ABNORMALS COMMENTARY

**PROPOSED RESIDENTIAL DEVELOPMENT
KERESFORTH ROAD, DODWORTH,
BARNSELY**

CP VIABILITY

OCTOBER 2025

Detail
PRELIMINARY CUT & FILL PLAN

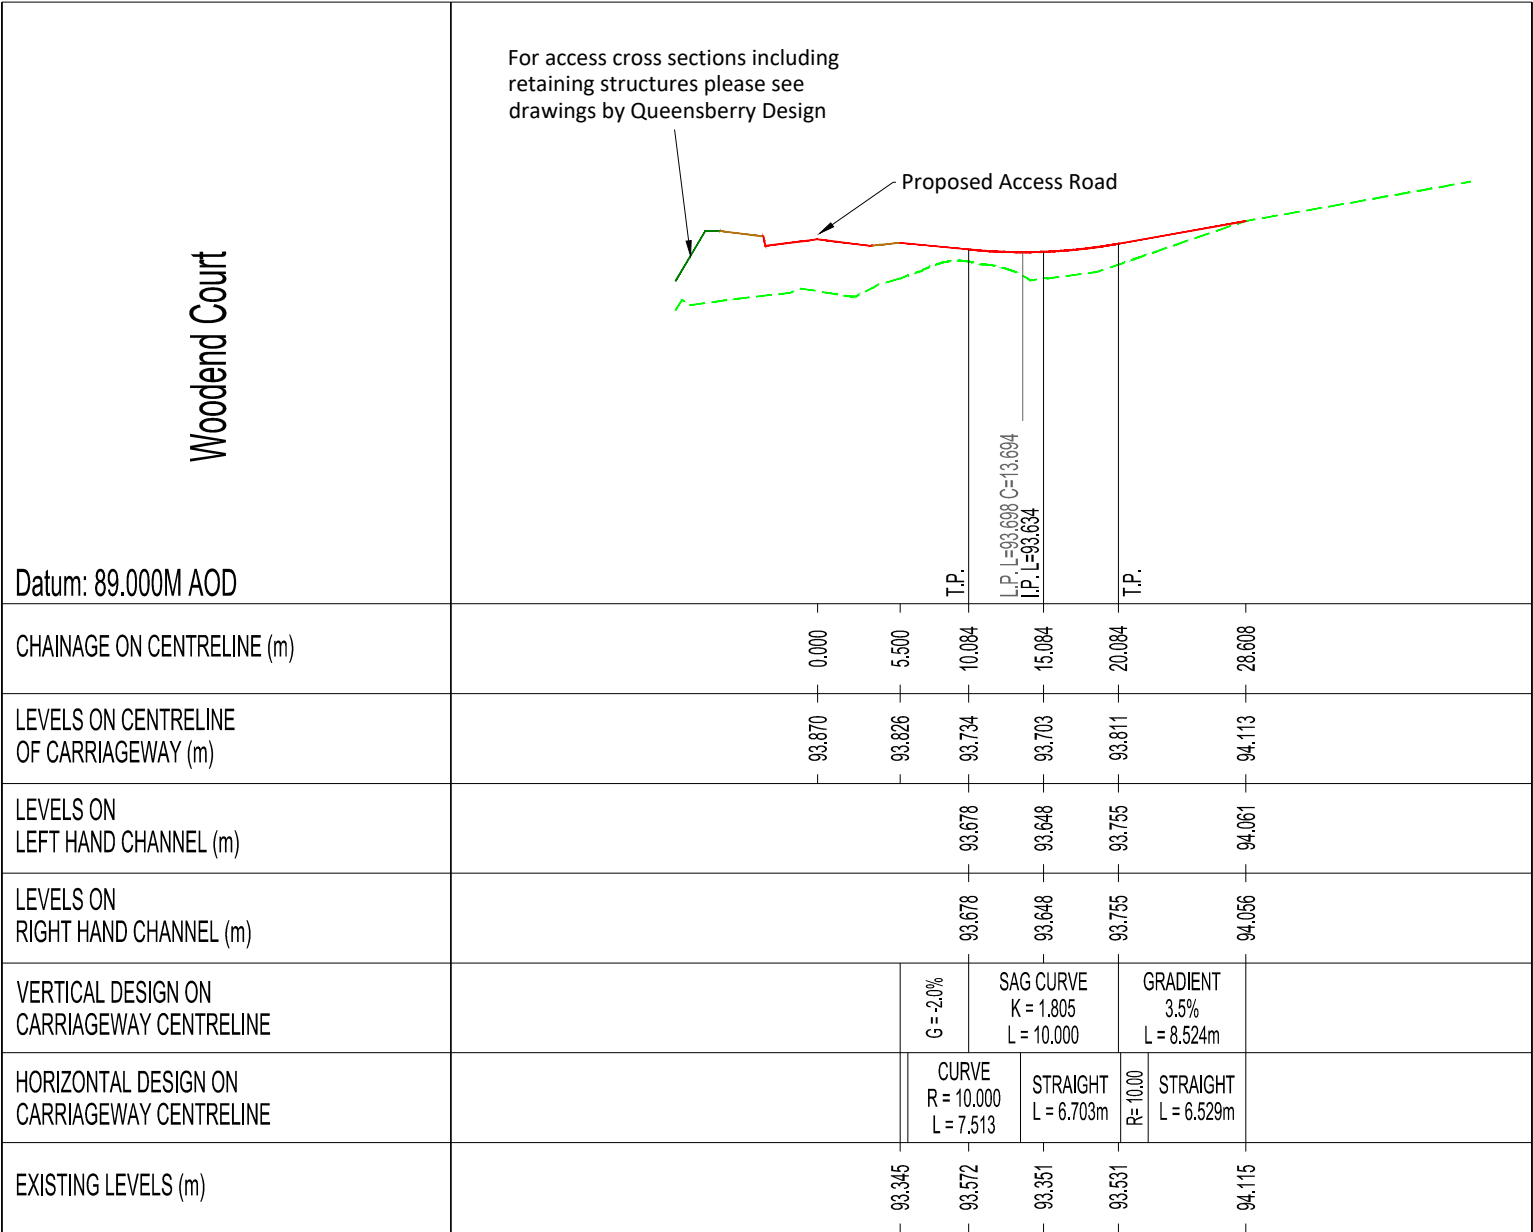
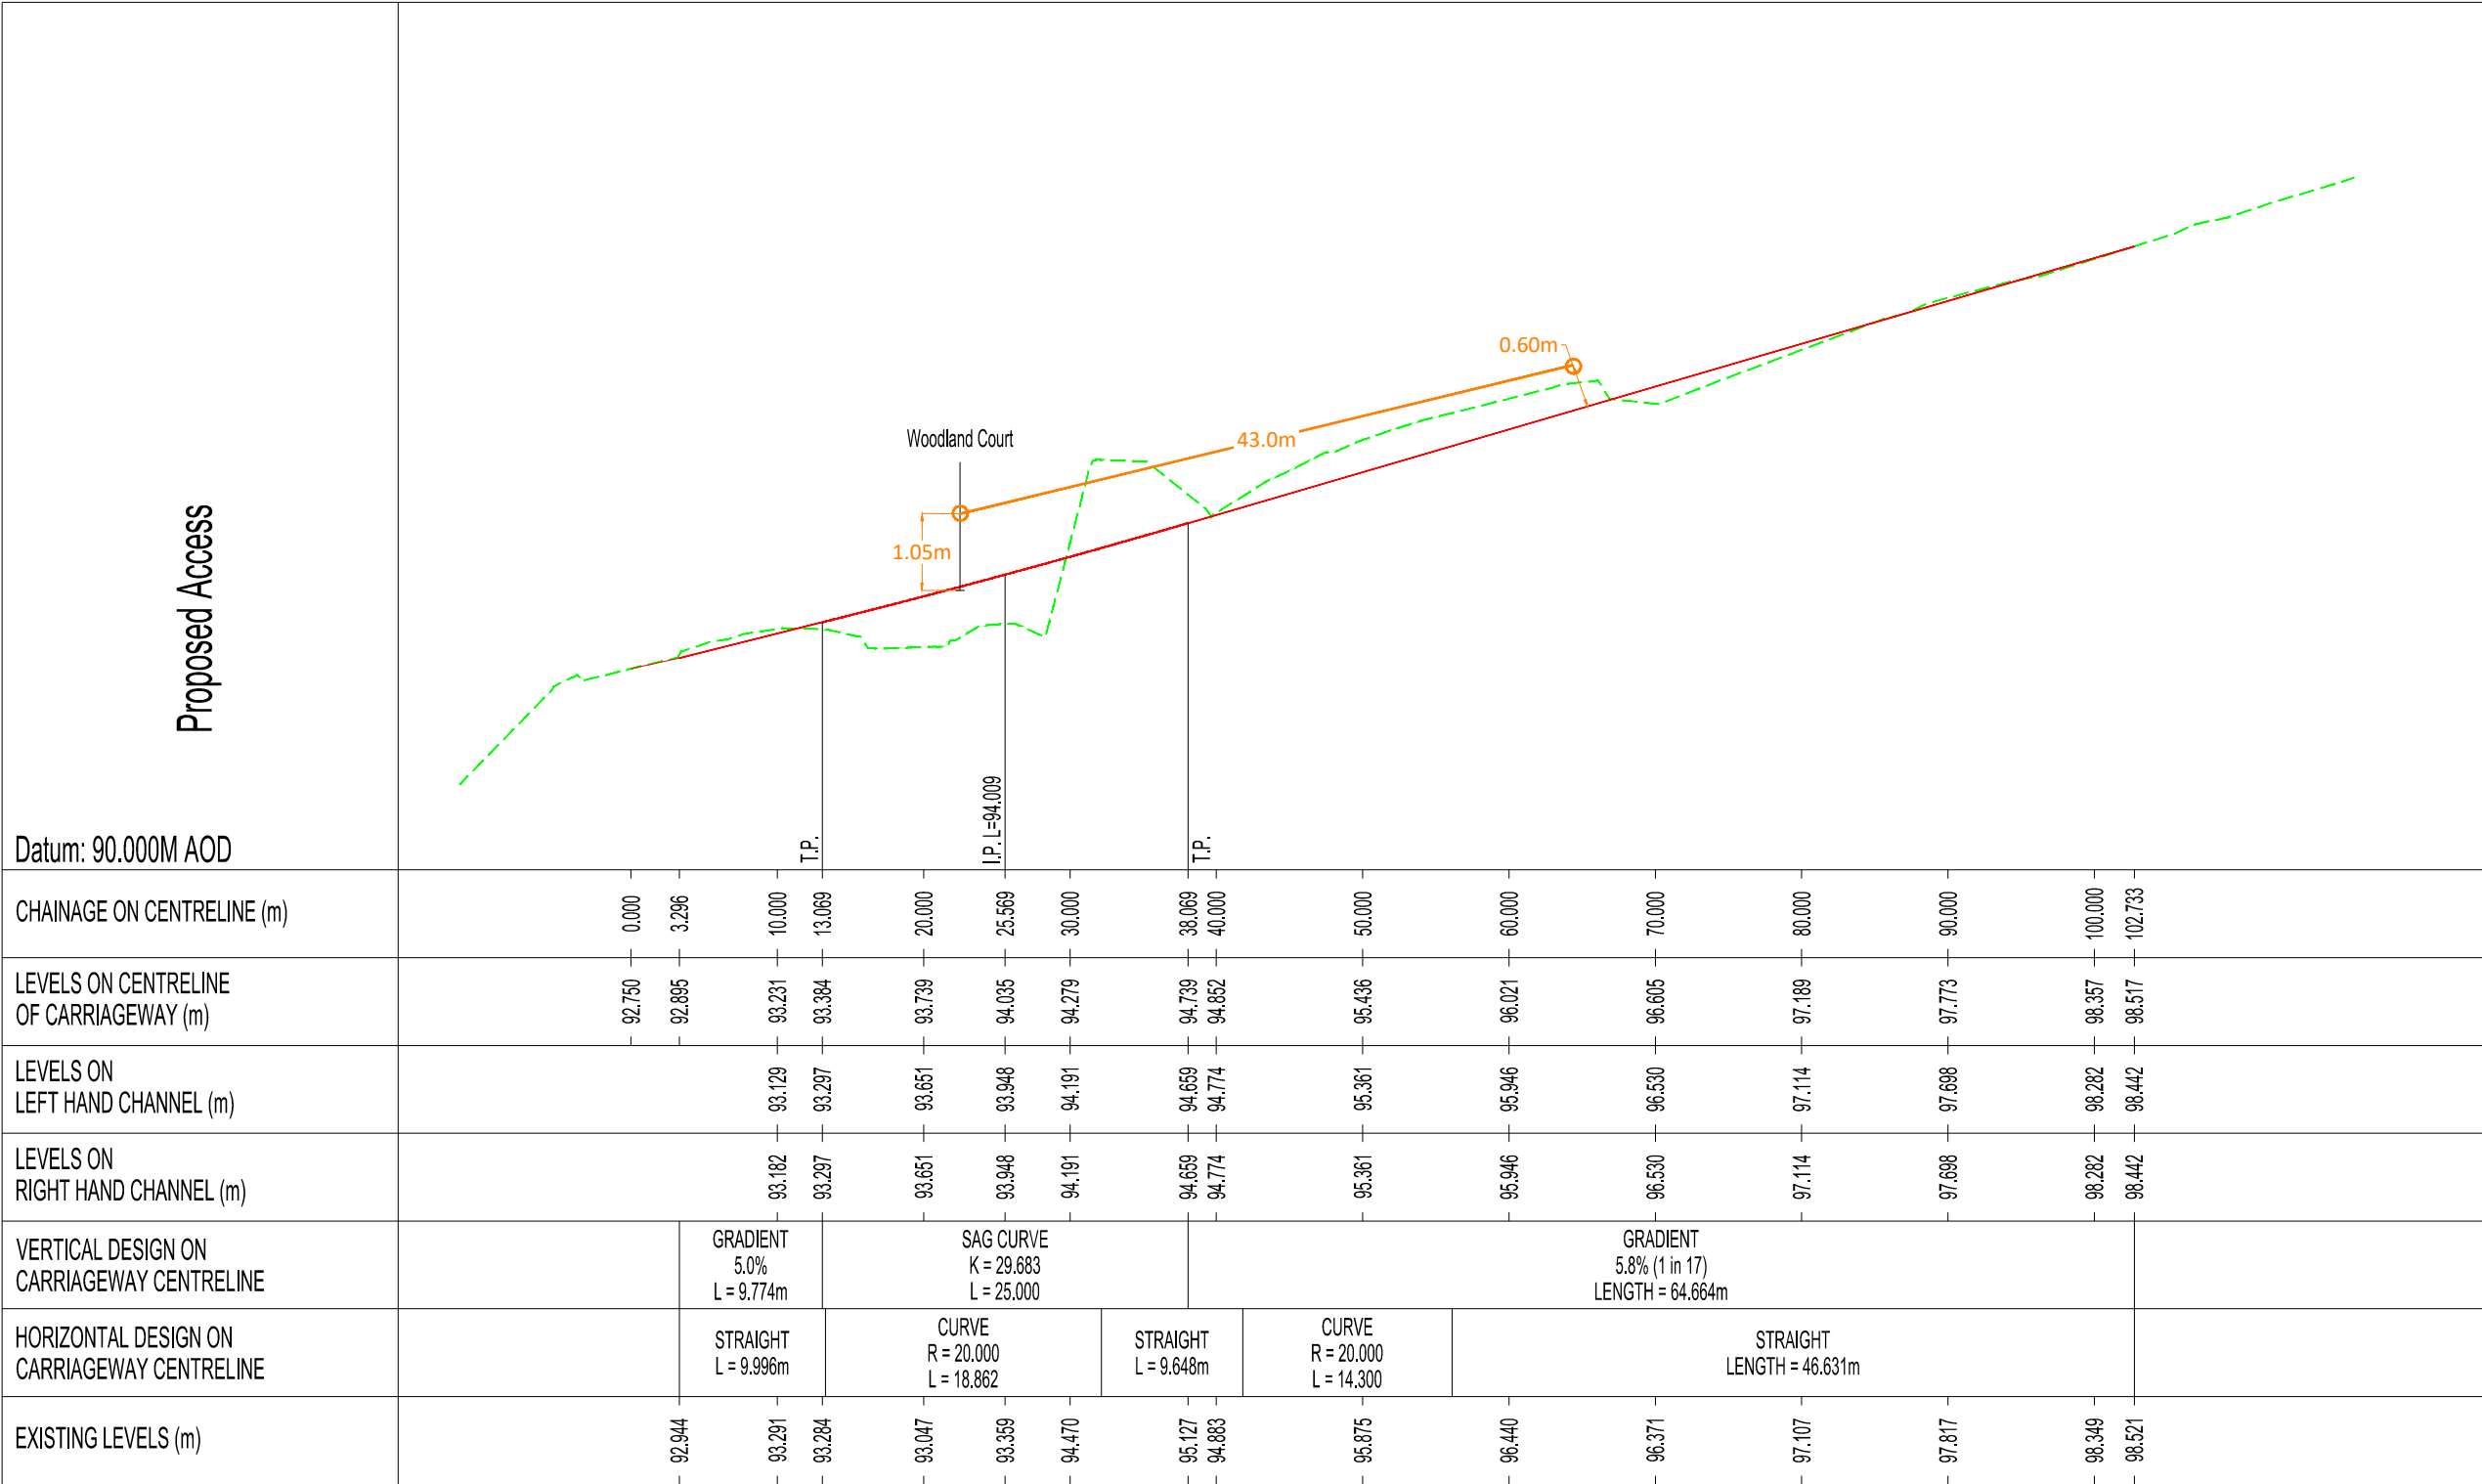
We note significant areas scheduled for cut & fill, and we are happy to adopt the figure of £529,485.09 included in the FVA.
